11/3/2020

SUBJECT: SFD2008-0044
SINGLE FAMILY DWELLING

Here are the results of all Inspections located at **5036 CHRISTIAN LIGHT RD:**

CRAWL SPACE FRAMING PLAN  
 1/8" = 1'-0"

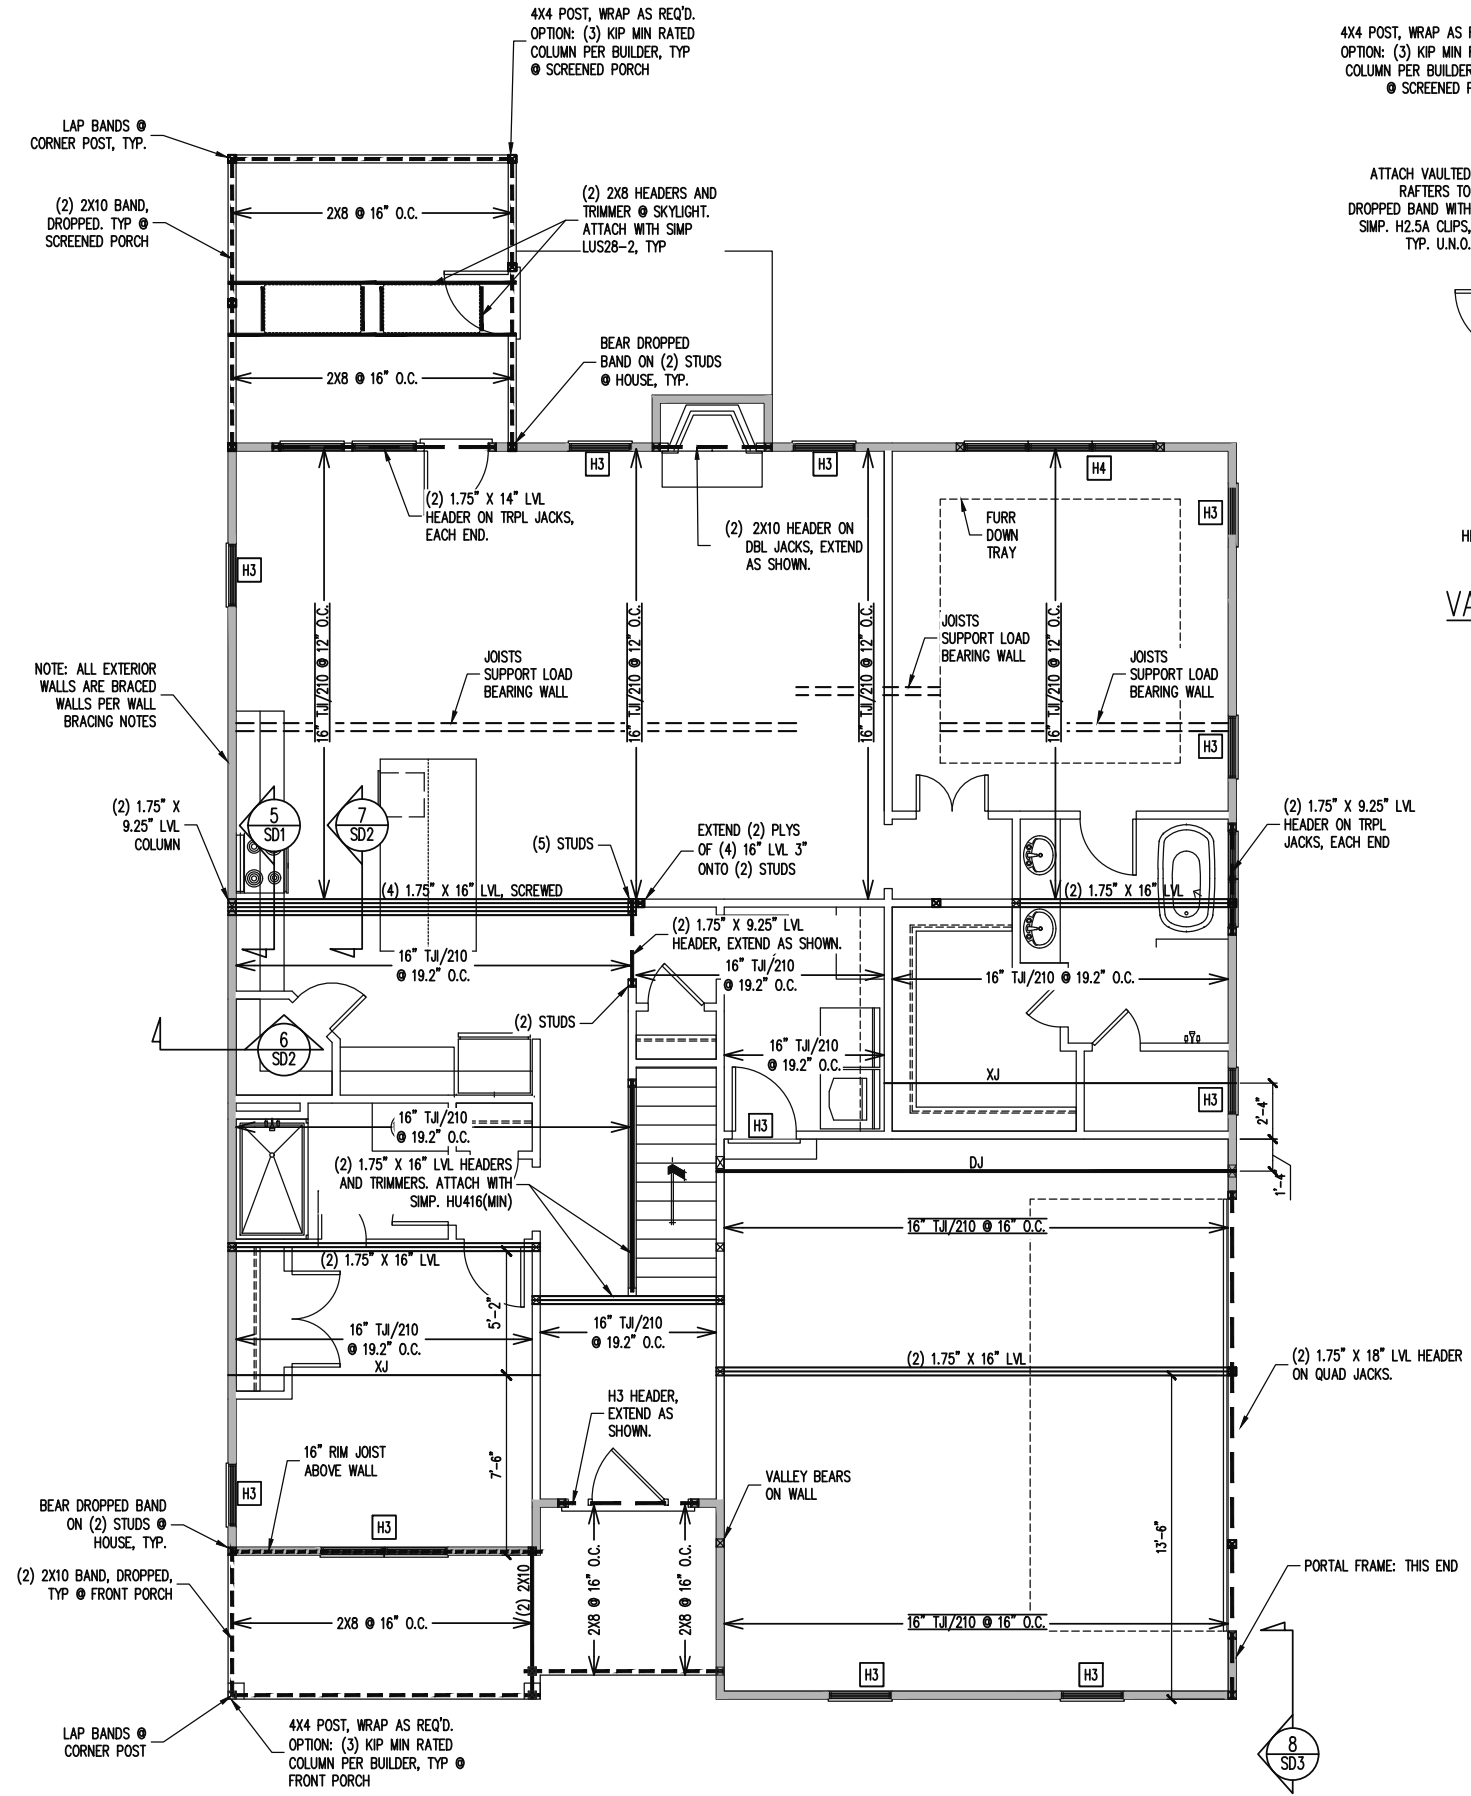
Inspection Type: OPEN FLOOR
Scheduled Date/Time: 10/5/2020 Any
Completed Date/Time: 10/5/2020
Inspector: Ray Holder
Result: DISAPPROVED
Remarks: eTRAKiT Inspection Request
Notes: 10/2/2020 12:06 PM Triple A Homes, Inc.

Missing I-joint blocking in 2 places, I circled on 1st floor layout.
